DRB Application No.: 04DRB-01976 (P&F)
Project Name: RAFAR INVESTMENTS
Agent: Surveys Southwest

**CITY OF ALBUQUERQUE
PLANNING DEPARTMENT
JANUARY 5, 2005
DRB Comments**

RE: Rafar Investments/ minor plat

PLAT OF
 LOT B-1, RAFAR INVESTMENTS &
 A.M.A.F.C.A. PARCEL A
 PROJECTED SECTION 14, T. 11 N., R. 3 E., N.M.P.M.
 ELENA GALLEGOS GRANT
 CITY OF ALBUQUERQUE
 BERNALILLO COUNTY, NEW MEXICO
 SEPTEMBER 2004
 SHEET 1 OF 2

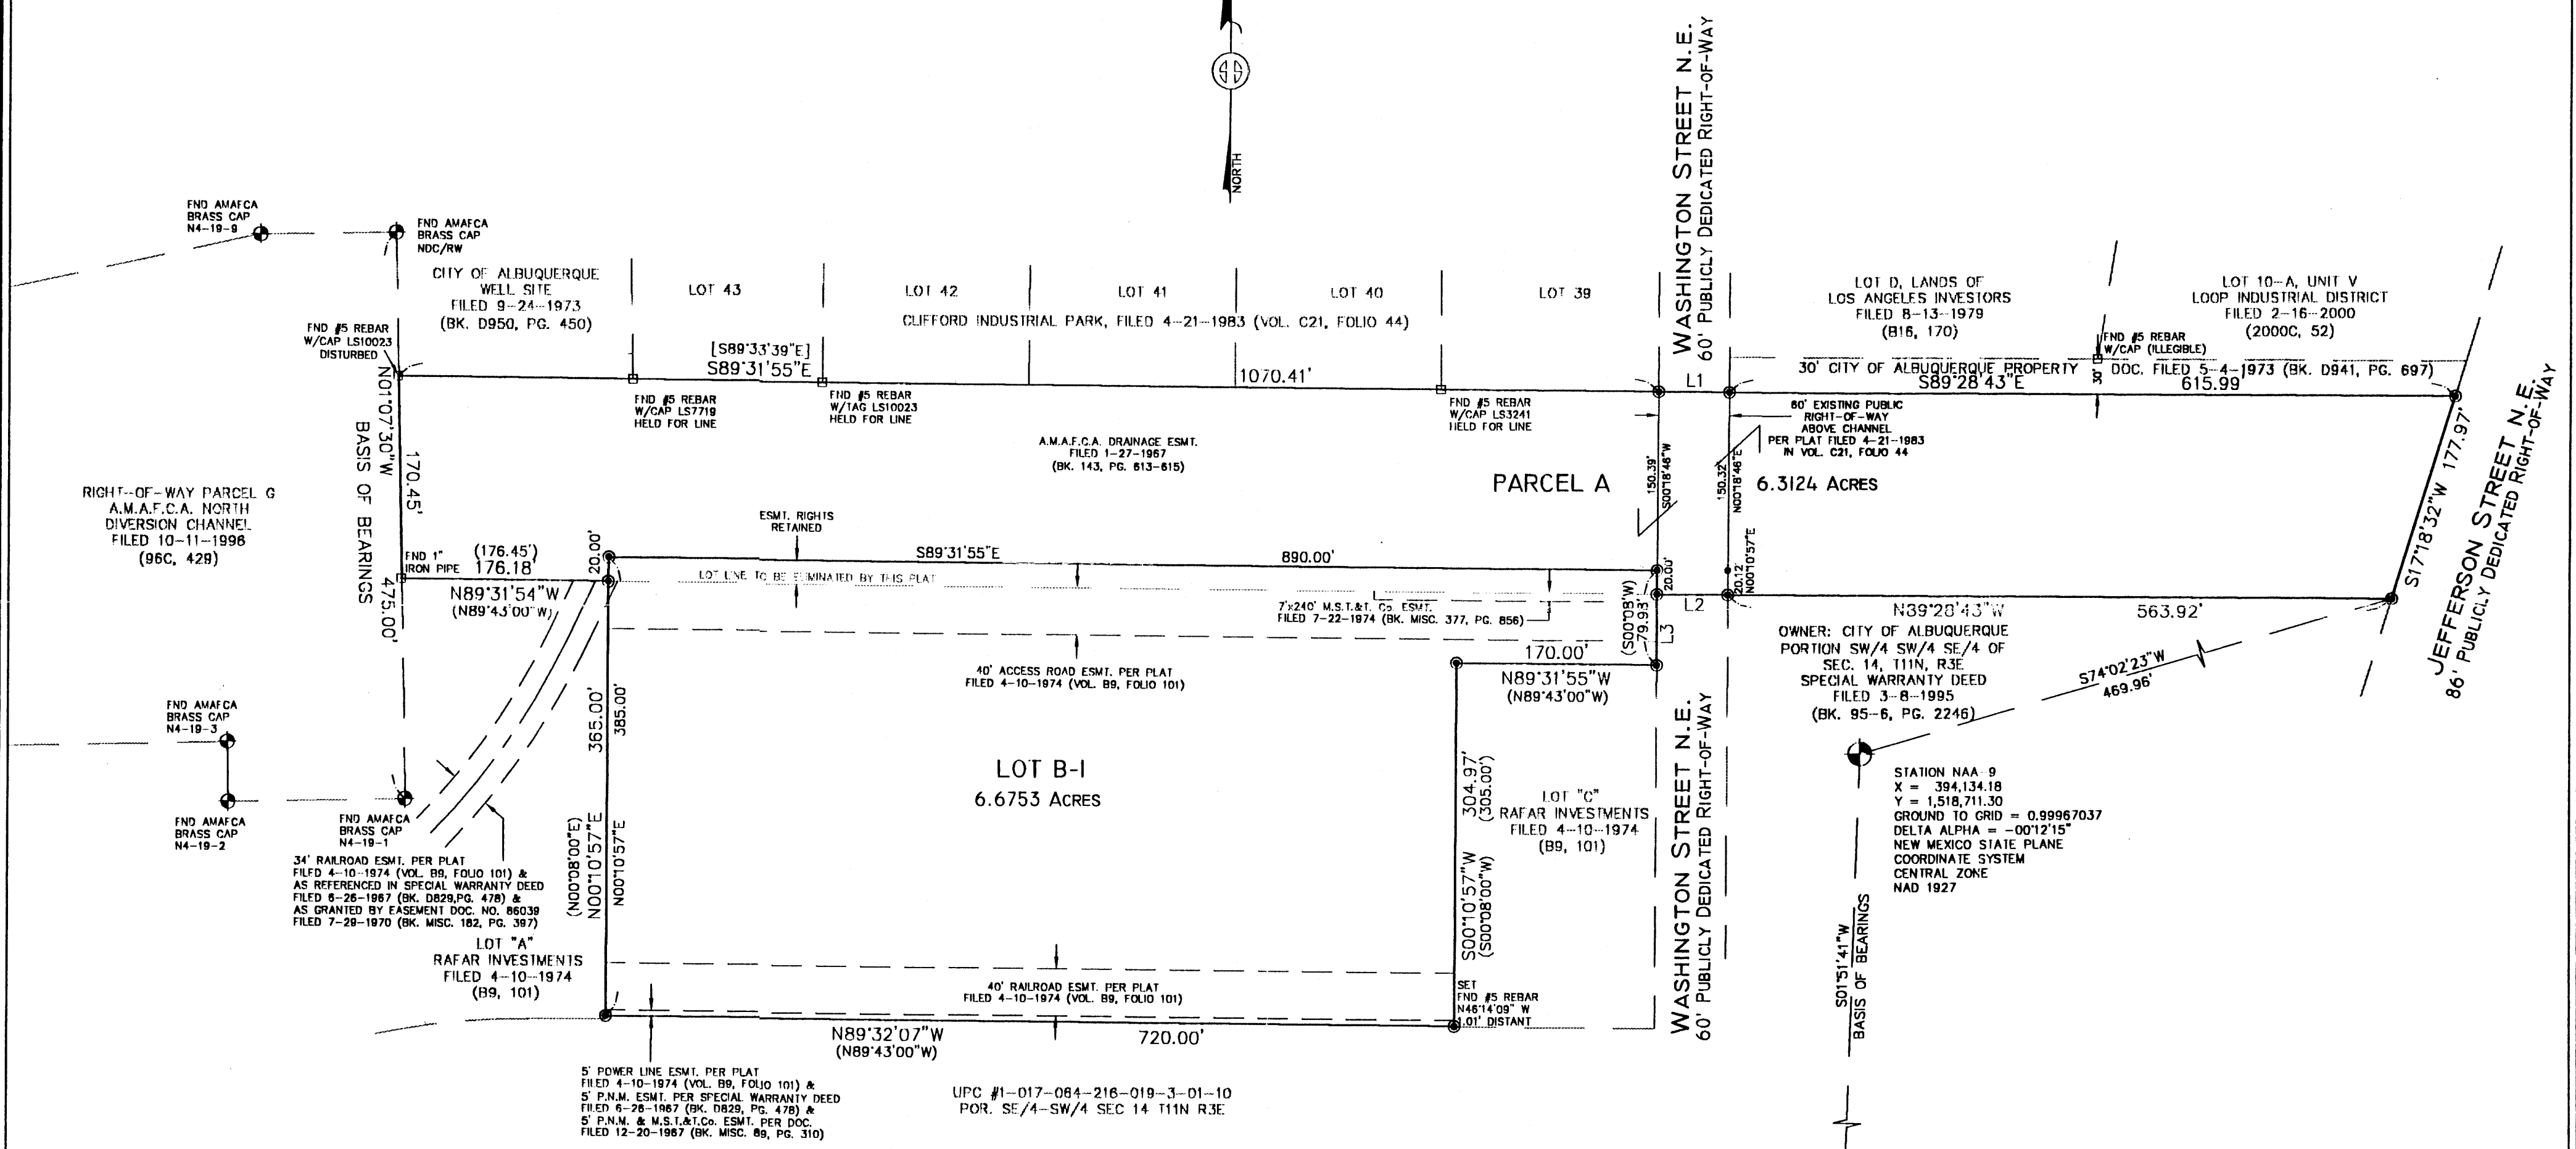
This property is in the North I25 Sector Plan area. If the property is developed, there should be an existing DRB approved site plan for subdivision. When was the property developed?

If there is such a plan existing, it may need amending before the plat is approved.

- 1) Where is purchase agreement for 20' of underlying fee of Parcel "A"?
- 2) Who owns Parcel "A"?
- 3) Shouldn't the 60' public right-of-way separate Parcel "A"?

Property Management may have to sign plat.
Department of Municipal Development needs to approve configuration prior to City Engineer sign-off.
